APPALOOSA HIGHWAY 24 SUBDIVISION

FILING NO. 2

Markup Summary

GRADING AND EROSION CONTROL PLAN
APPALOOSA HIGHWAY 24 SUBDIVISION FILING NO. 2
EL PASO COUNTY, COLORADO

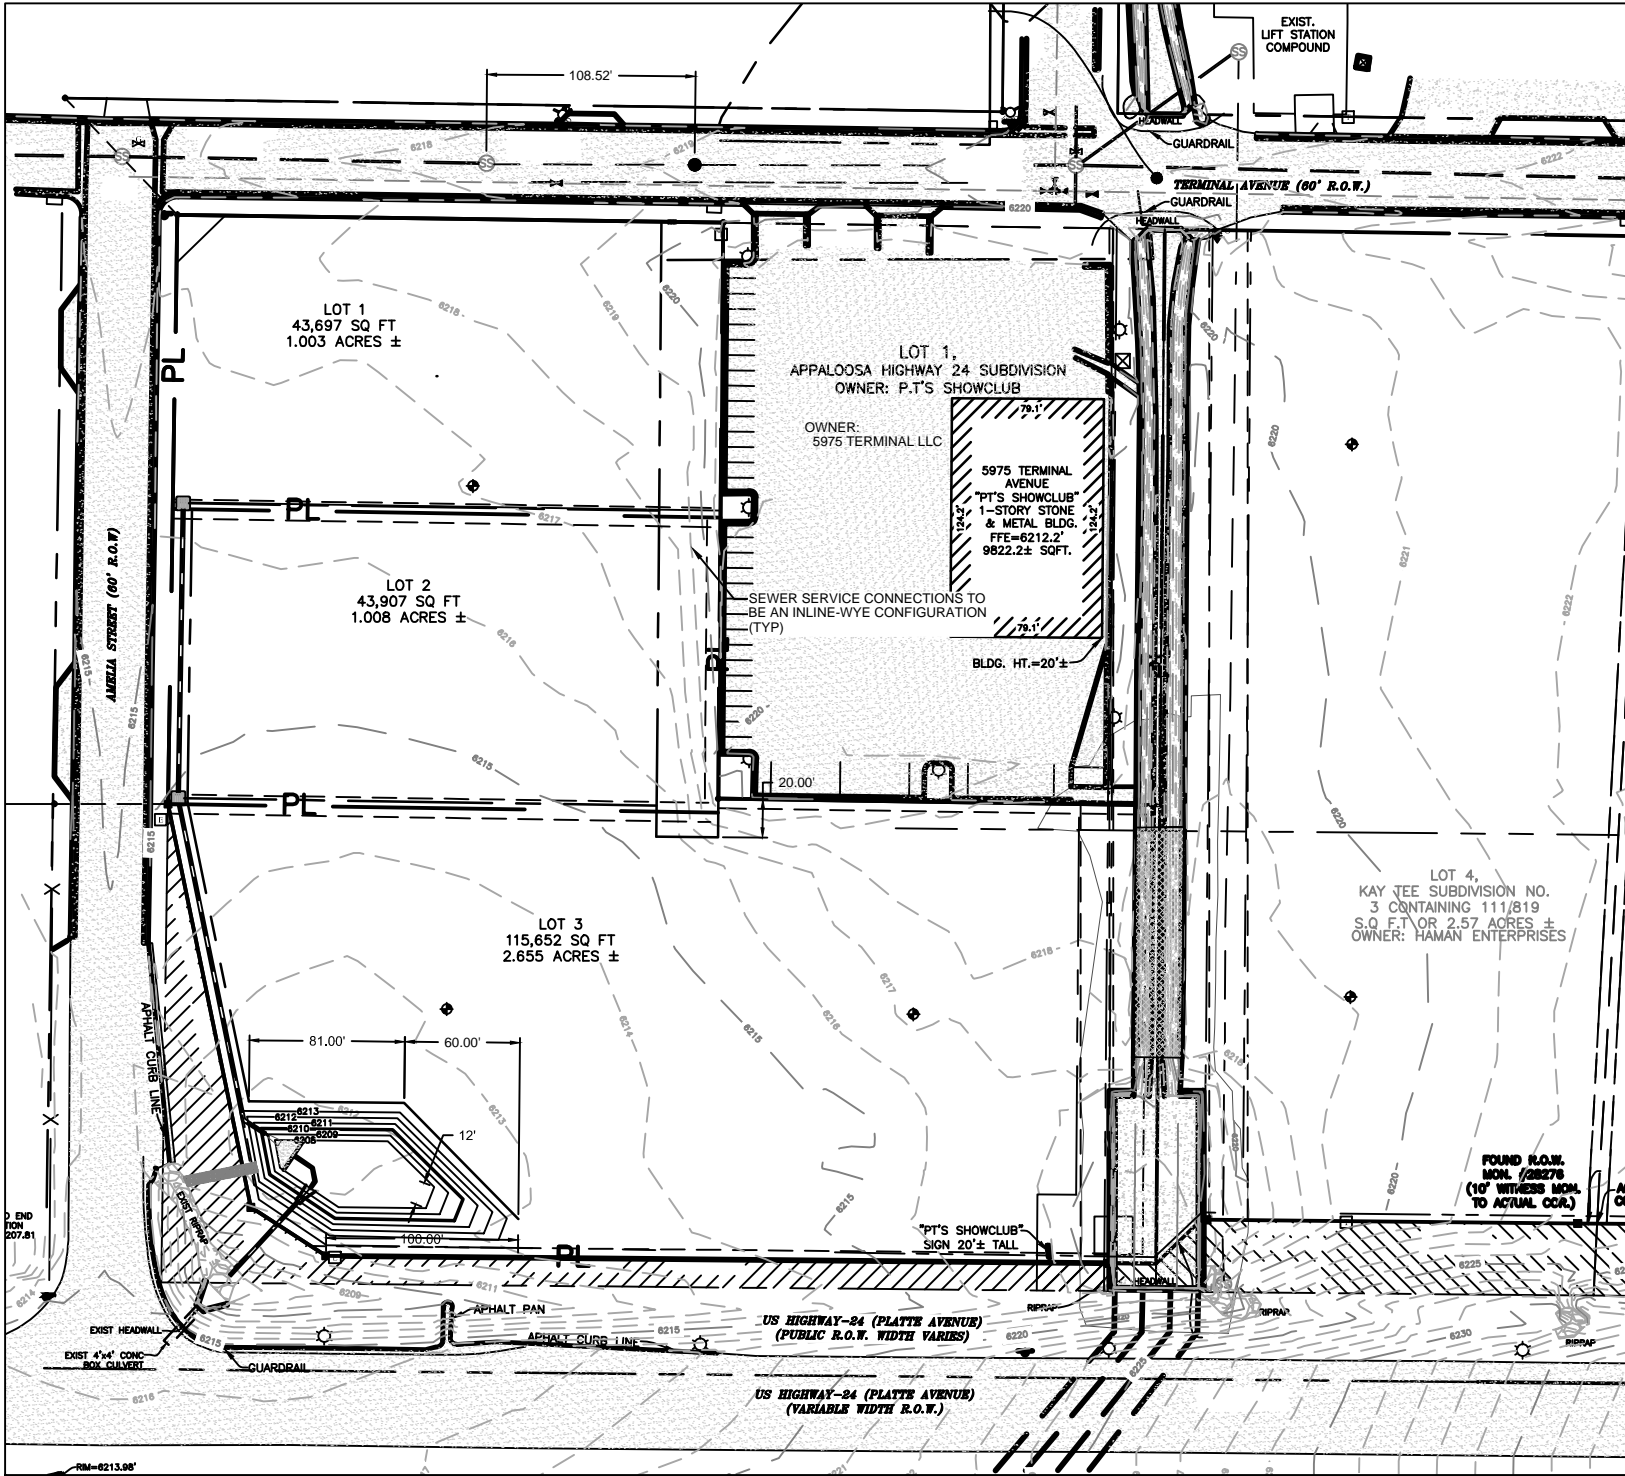
Change "Development Services" and "DSD" to "Planning and Community Development" and "PCD", where applicable.

Add PCD File "VR1813"
